Our Case Number: ACP-323849-25

An
Coimisiún
Pleanála

Re: The proposed development is for a mixed use development that seeks the regeneration and adaptive reuse of a strategic brownfield site, as part of the Limerick City and County Council 'World Class Waterfront revitalisation and transformation project' 'Cleaves Riverside Quarter' in the townland of Farranshone More in Limerick City.

Quarry Fifth and Sixth Level Floor Plan – Proposed

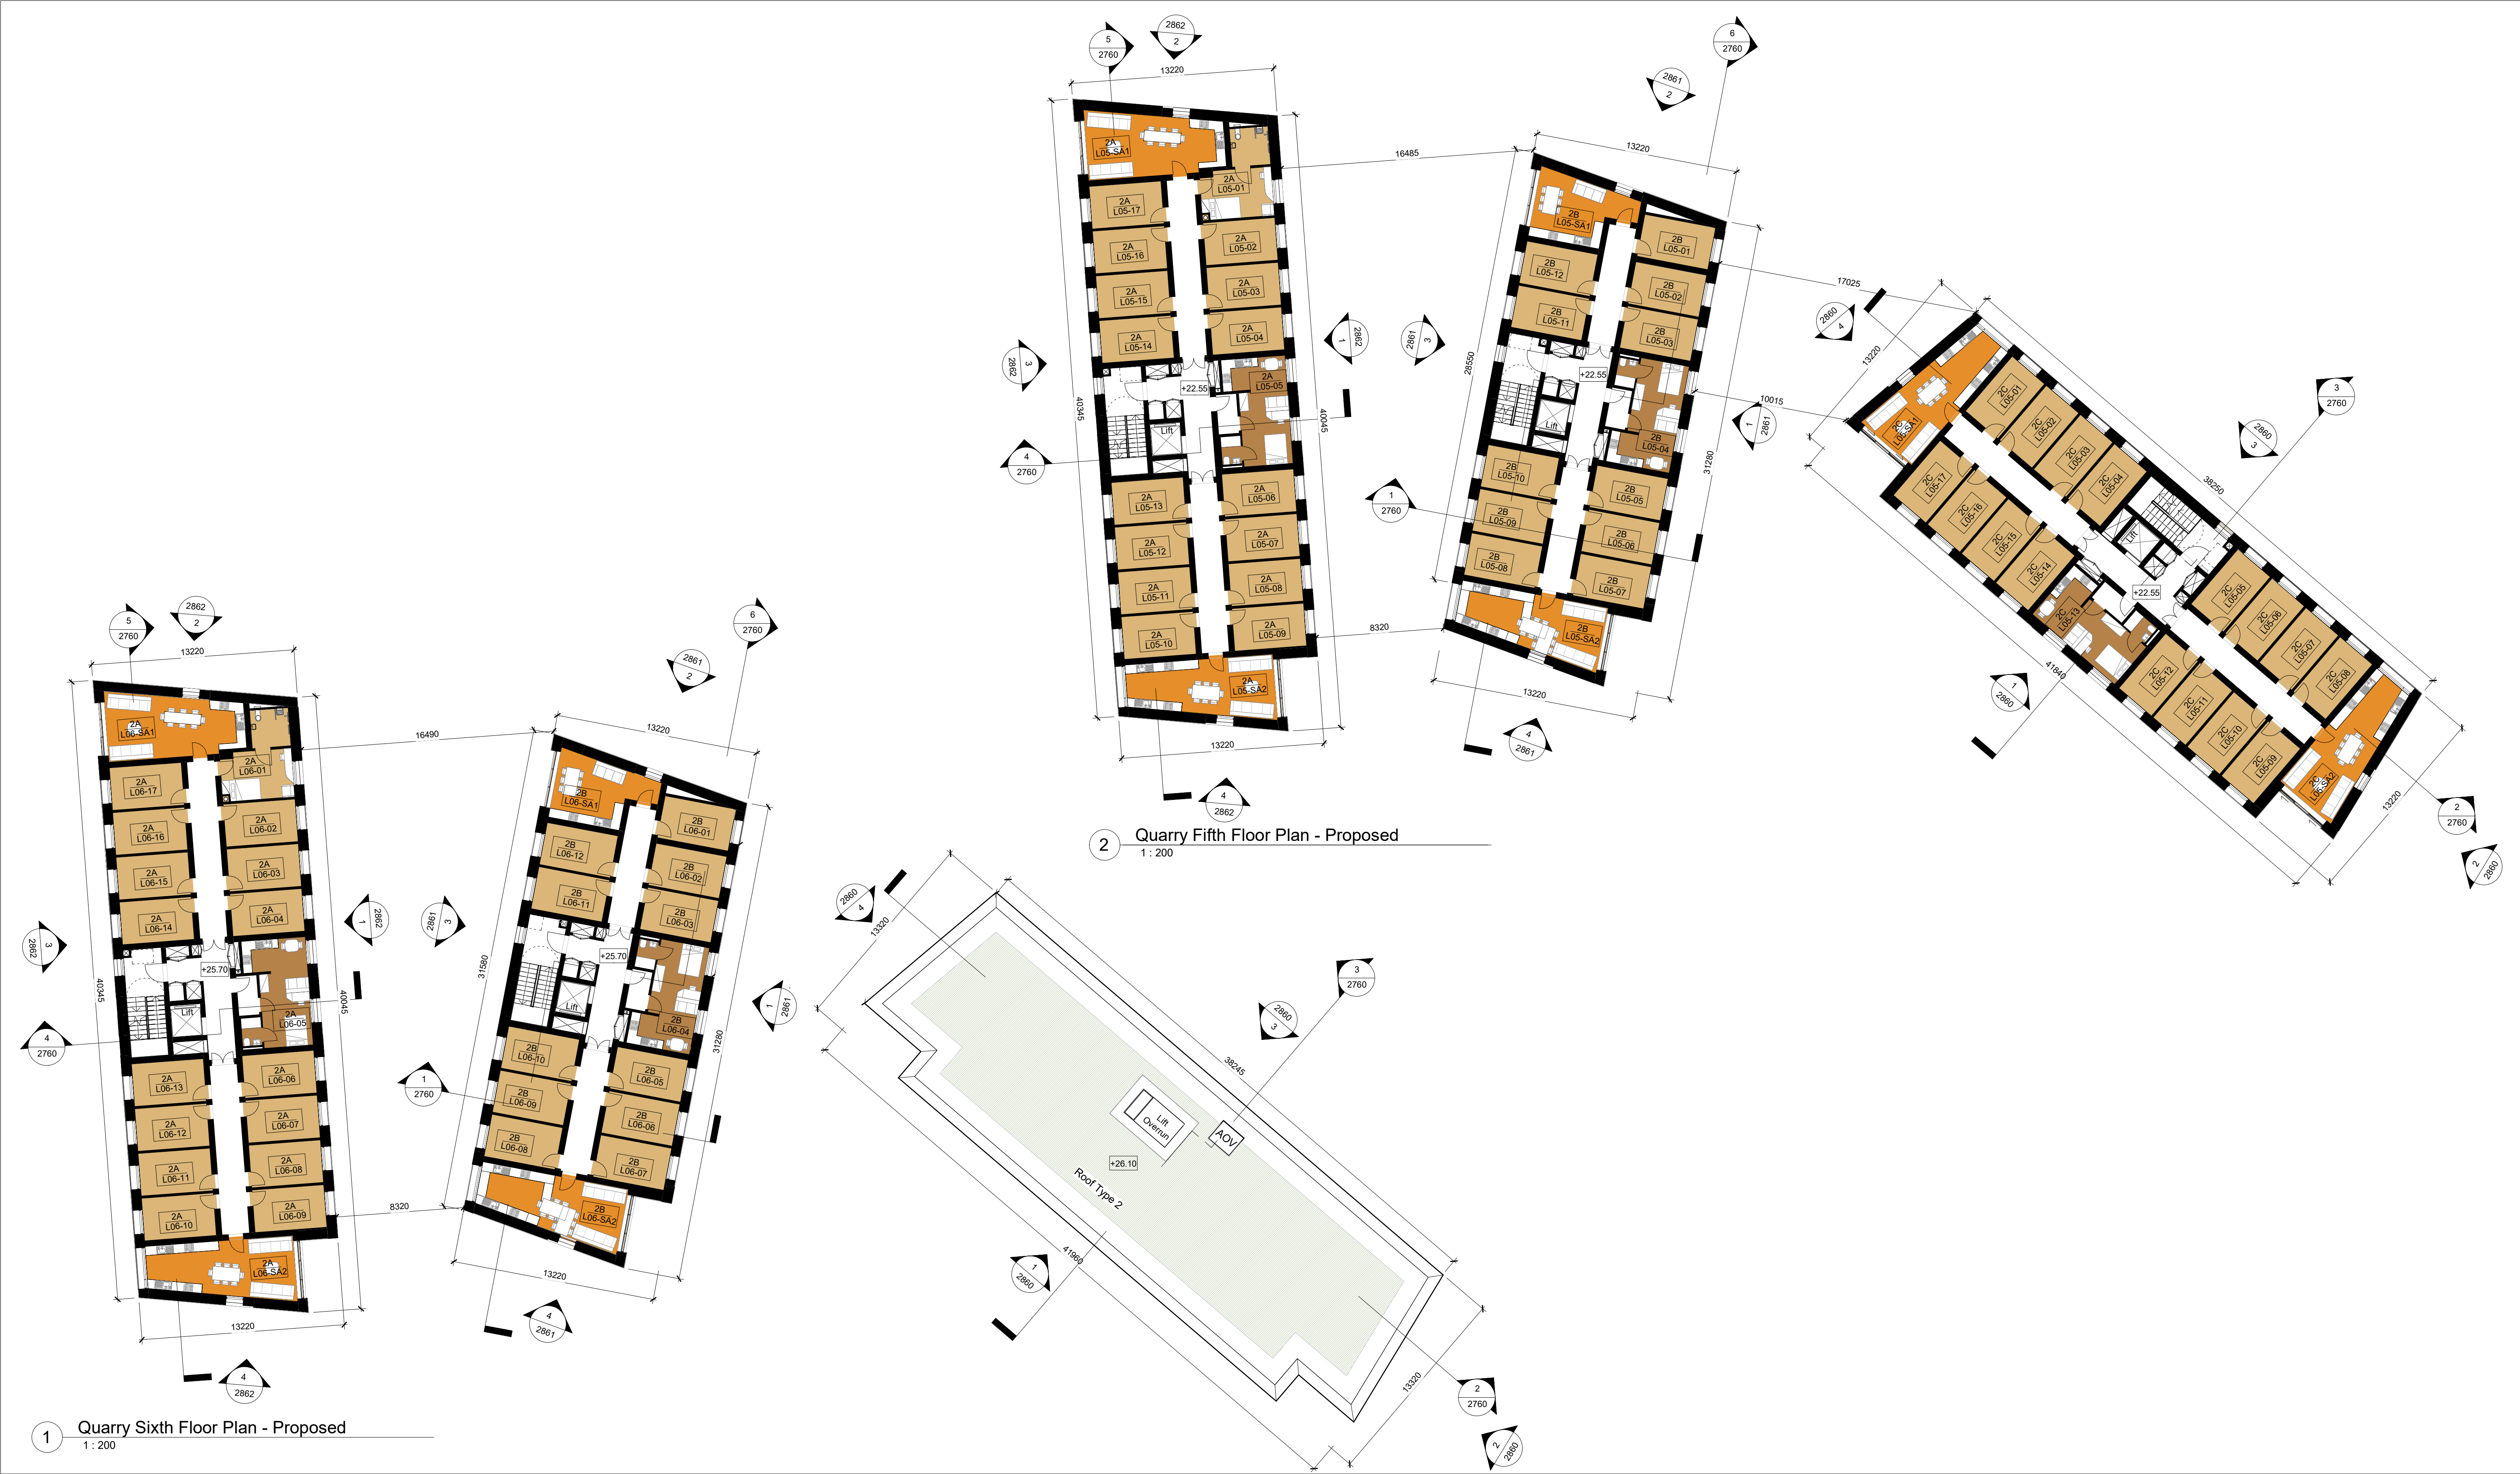
- In regard to Purpose Built Student Accommodation located within the Quarry Zone, block 2A and block 2B as per drawing title "Quarry First and Second Floor Plan – Proposed" and drawing title "Quarry Third and Fourth Level Floor Plan – Proposed" and drawing title "Quarry Fifth and Sixth Level Floor Plan – Proposed" and the Planning Statement highlights that 21% of the overall bed spaces provided have reduced separation distances as follows 24no. rooms are separated at a distance of 14.5m – 15.5m, 22 no. rooms are separated by a distance of 11m – 12.5m and 11 no. rooms have a 11m separation distance. The proposed separation distances are below the required 16 metres as per Compact Settlement Guidelines SPPR 1. You are requested to revise the site layout at a scale of 1:200 demonstrating the purpose-built student accommodation in compliance with the required minimum separation distance as per Sustainable Residential Development and Compact Settlements Guidelines for Planning Authorities.

drawing no. CRQMP-BMEA-3X-00-DR-AA-2020

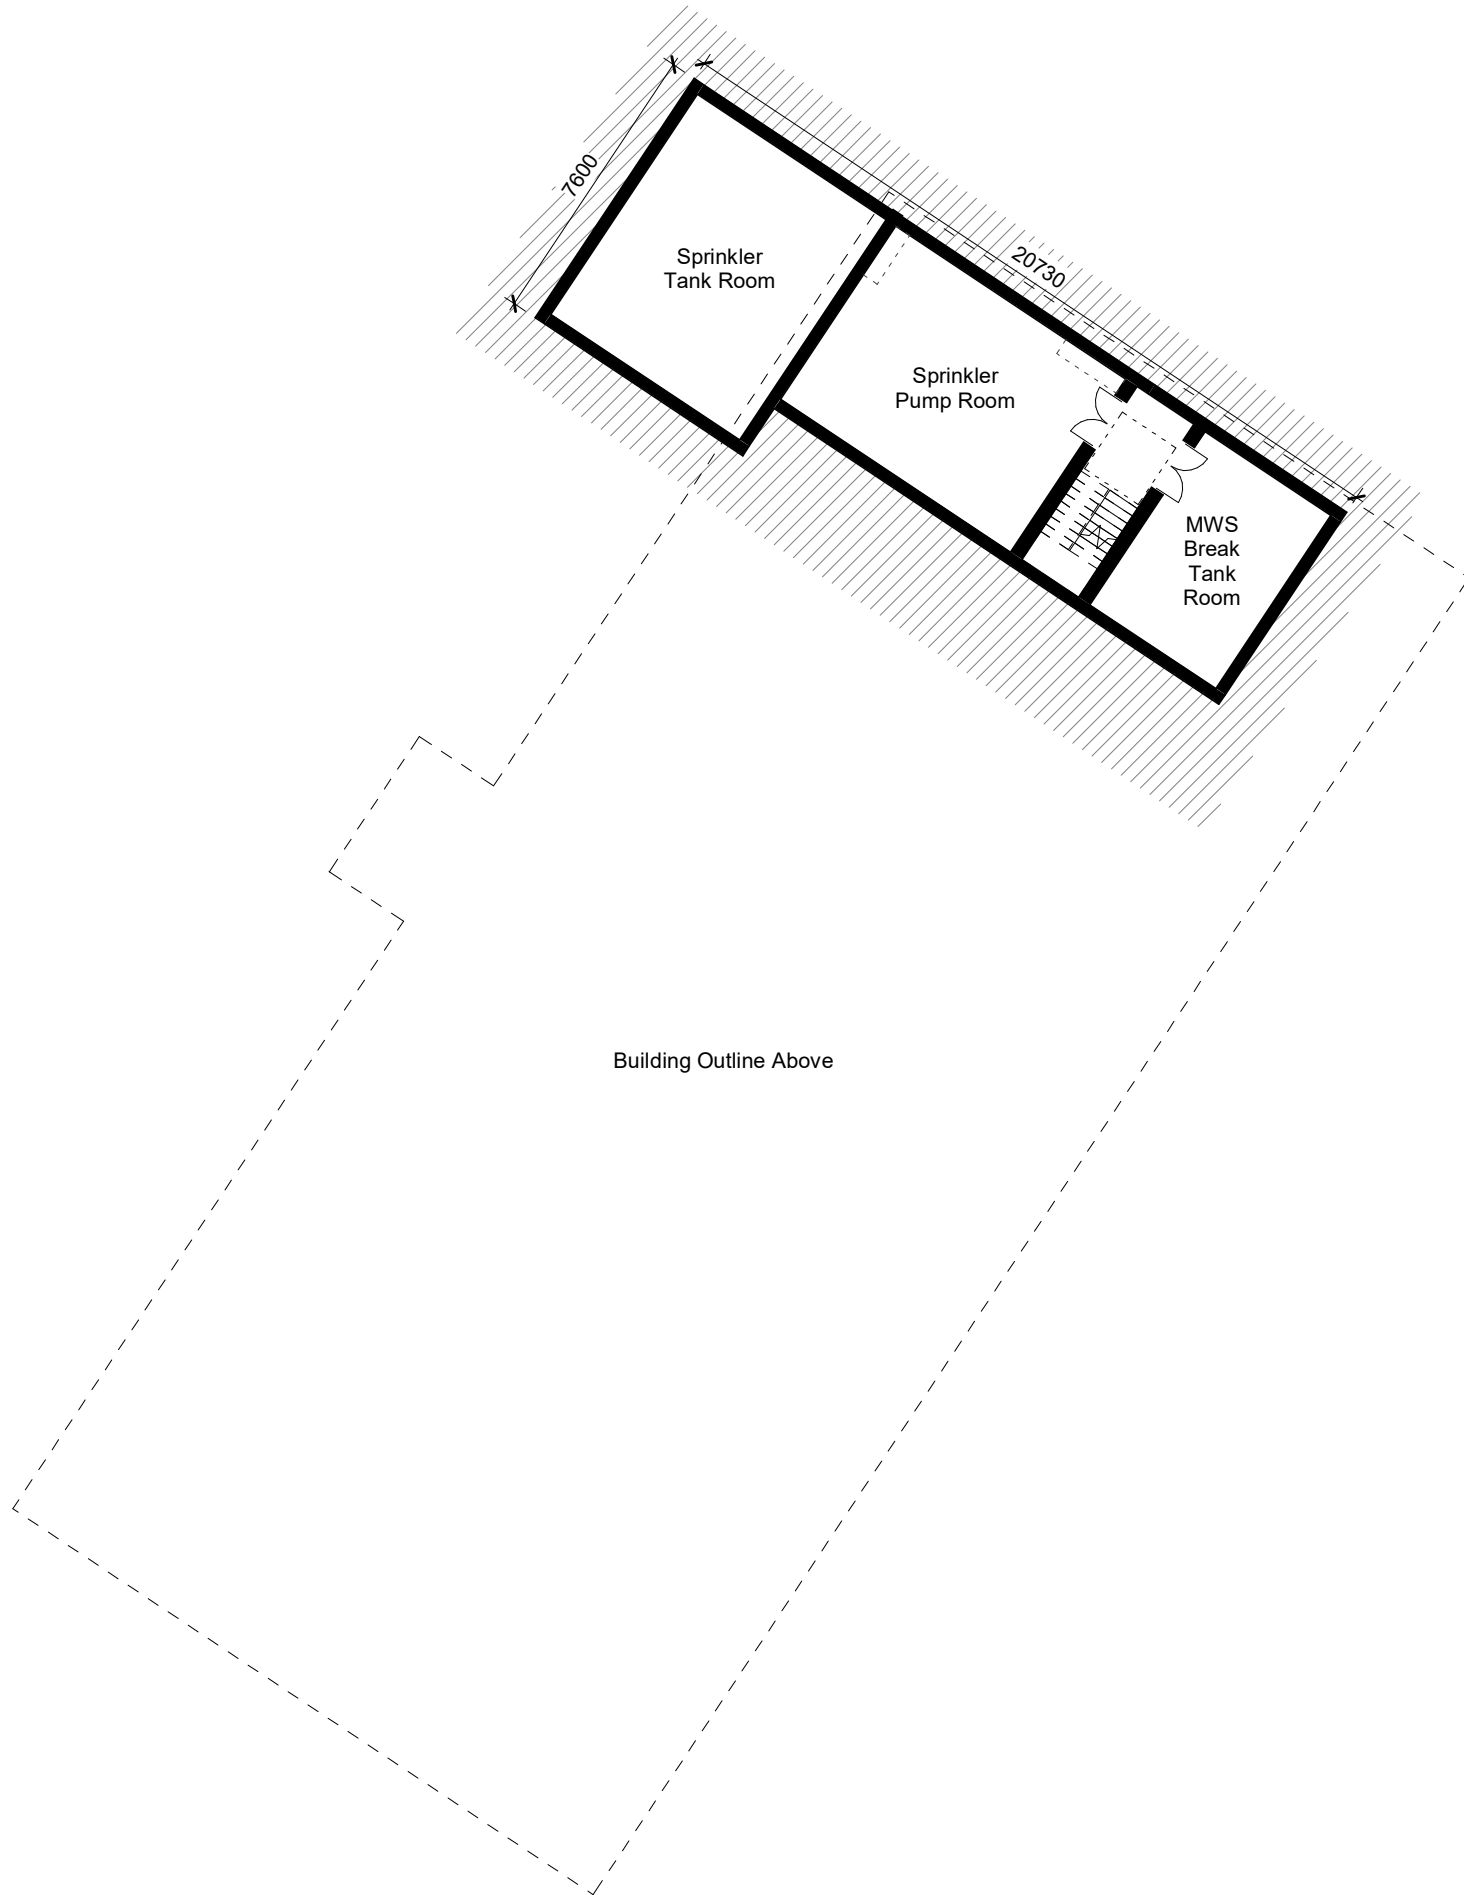
- In relation to Stonetown Terrace Zone, drawing title "Stonetown Terrace Ground Floor Plan – Proposed", drawing no. CRQMP-BMEA-3X-00-DR-AA-2020 indicates a new retaining wall to the northern and western boundary of the subject site. You are requested to submit details of the

proposed new retaining wall including the materials proposed and details of the proposed infill between the retaining wall and the adjoining site boundary. In addition, you are requested to submit drawings including elevations and sections at a scale of 1:50.

- Drawing title "Stonetown Terrace Ground Floor Plan – Proposed", drawing no. CRQMP-BMEA-3X-00-DR-AA-2020 provides dimensions for each of the rear private gardens of the proposed Stonetown Terrace units, the proposed private rear open space does not correspond with the private open space area indicated in the Housing Quality Assessment. You are required to provide a minimum of 20sqm of private open space for the proposed Stonetown Terrace Units in accordance with Table 5.1 Minimum Private Open Space Standard for Houses, Sustainable and Compact Settlement Guidelines for the Planning Authorities.
